## **Sikh Grammar School, Rouse Hill – SSD 9472**

The Government Architect NSW (GANSW) has been asked to provide independent design review and commentary on State Significant Development application SSD 9472. Please find our response below.

- Property Boundary
- Extent of basement (below)

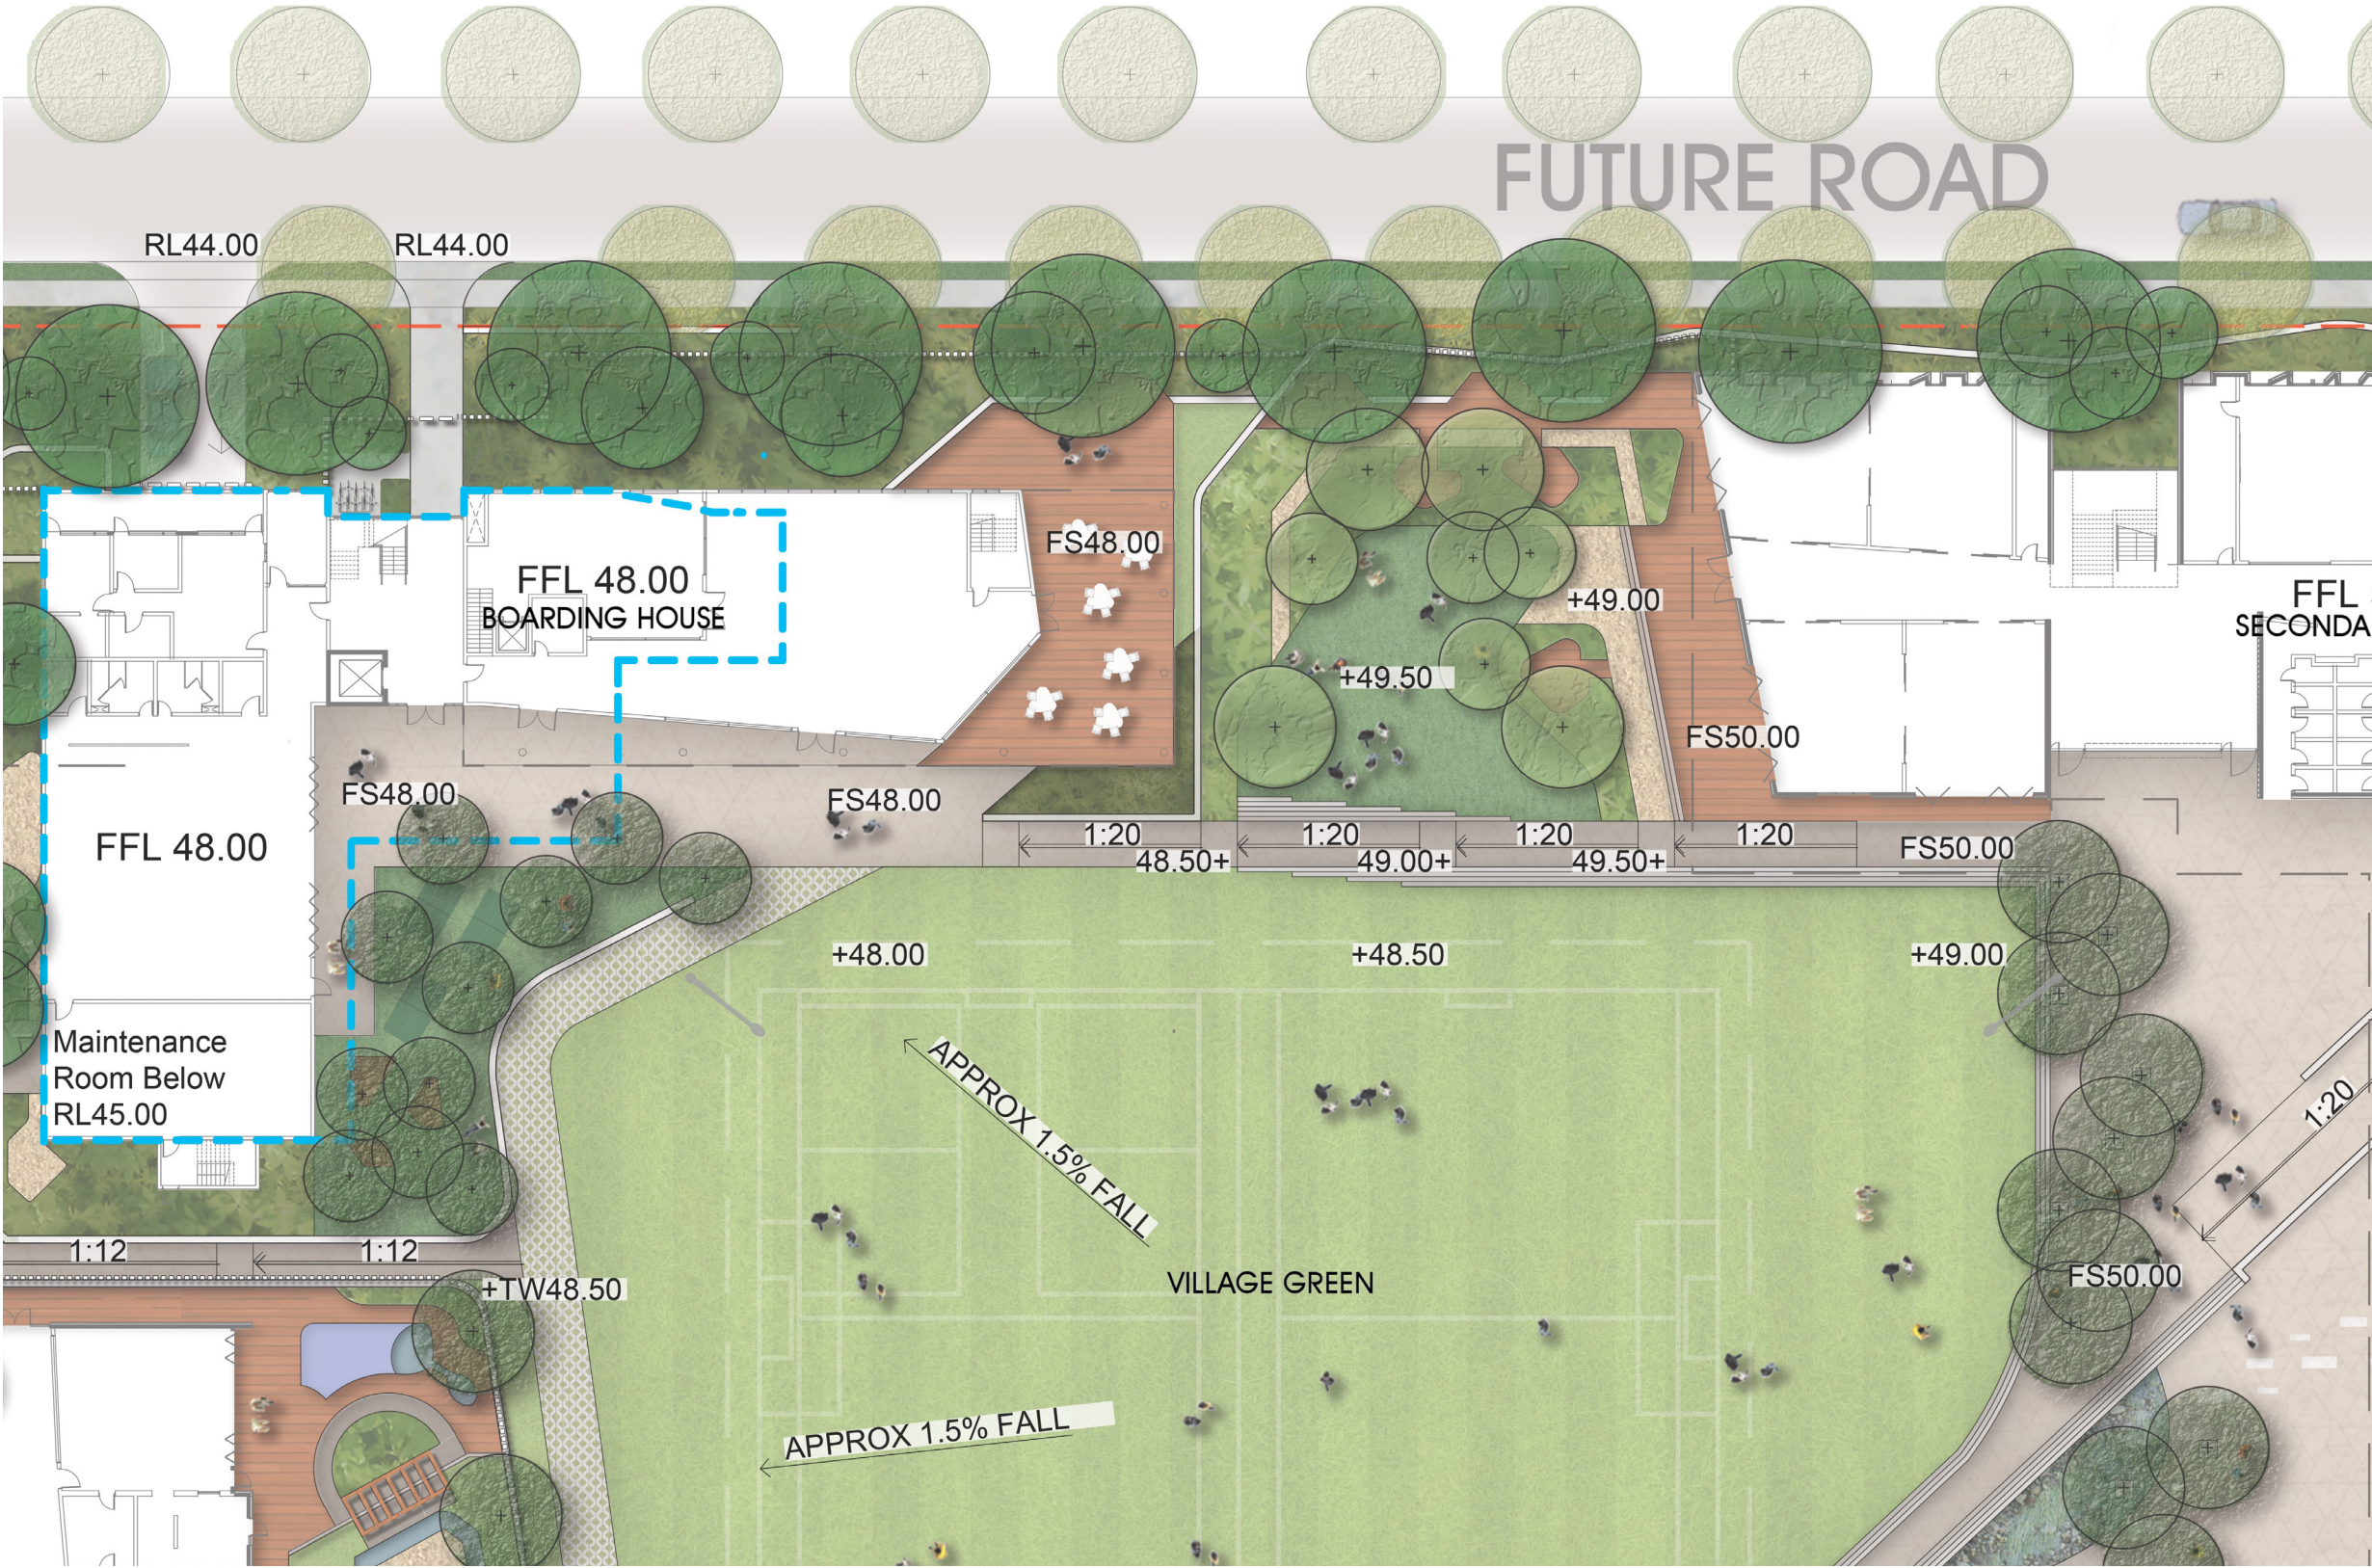
A short review of the layout and staged implementation of the canopy cover raises the concern that the canopy cover will not be achievable (as drawn) due to the variables of integration with future street landscaping under the DCP, project staging and the delivery/construction process generally: This includes:

- Spatial compatibility between future street trees and School perimeter planting.
- Insufficient space between the Secondary School & the north-west boundary for mature planting
- Deep soil ( min1500mm) depth for mature planting at locations with basement carparking under.

GANSW recommend a commitment to the (as proposed) canopy target – allowing for flexibility of location /distribution of trees relative to 1) shading quality/ maximum positive impact & 2) each stage of the project.

It is noted that areas such as the carpark to ELC interface are reliant on the street trees and could potentially cater for additional planting. This demonstrates the risk of reliance on factors yet to be determined (e.g finalise street tree layouts aligned with the DCP)
